## Local Policing Support Team

Our Ref: NW/ARU/19/20A

**RE: Land at Electrical Sub Station, Ford Road, Arundel. BN18 9DX**

Thank you for your correspondence of 20<sup>th</sup> August 2019, advising me of '38 No residential apartments (9 No 1-bed units & 29 No. 2-bed units) along with access, off-street parking, amenity space & enhancements to the local footpath network' at the above location, for which you seek advice from a crime prevention viewpoint.

NORTH-WEST ELEVATION TO
ACCESS ROAD

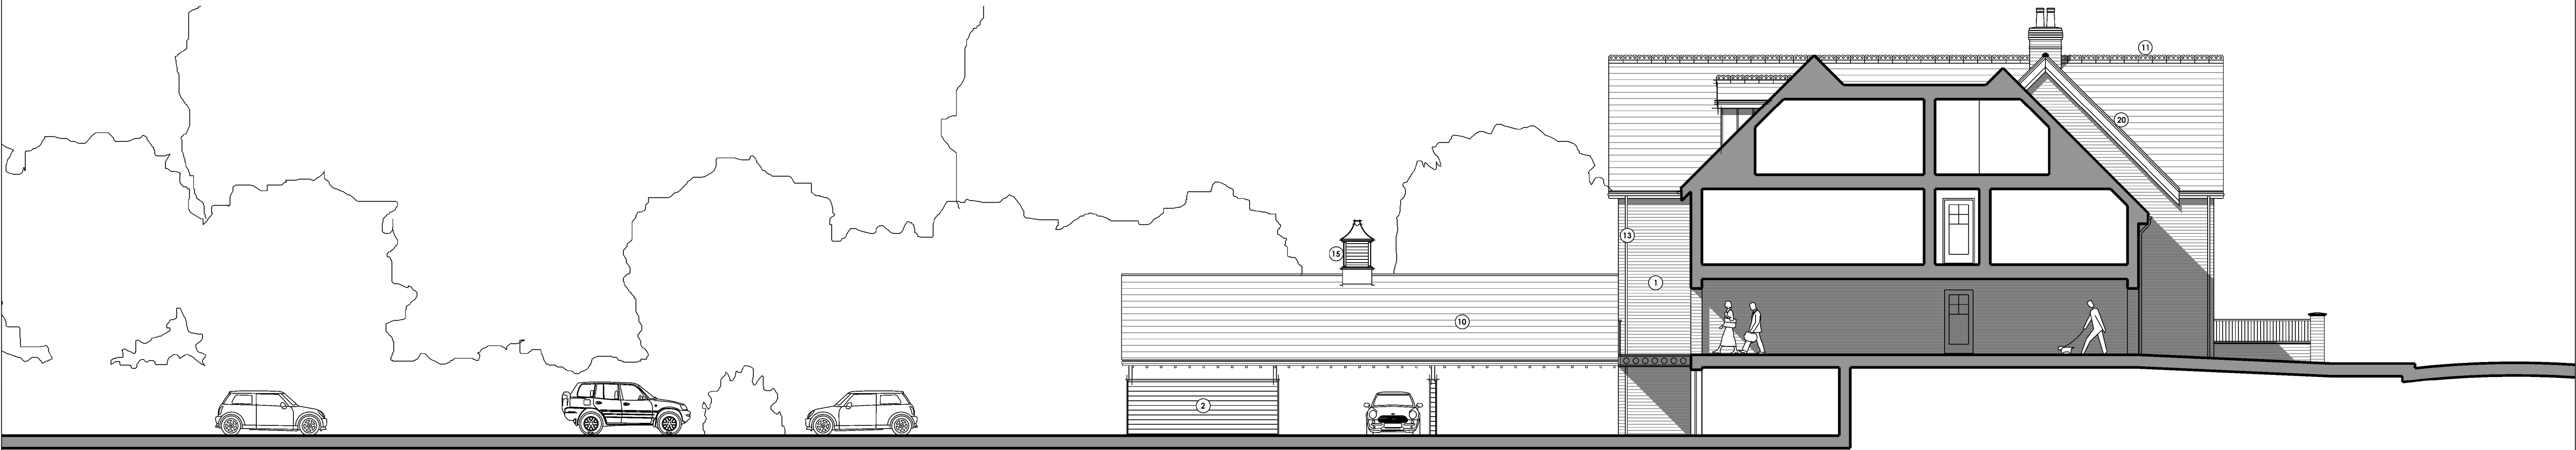
I have concerns regarding the vehicle entrance to the car park from the access road.

The double doors to the refuse stores on either side open onto the passageway for vehicles. At bin collection times this may cause conflict with the doors being open and vehicles driving through as the doors extend into the passage. It may also cause injury to the refuse operatives. The double doors should either be able to swing right back to an open position against the outer walls or be protected with bollards.

If the vehicle passage into the car parking area is also to be used by pedestrians, there should be a clear demarcation route for the pedestrians, such as well-defined surface paint markings.

The vehicle entrance has no security gate and so unauthorised access can be gained by members of the public at any time to parked residents' vehicles within the courtyard and under croft areas.
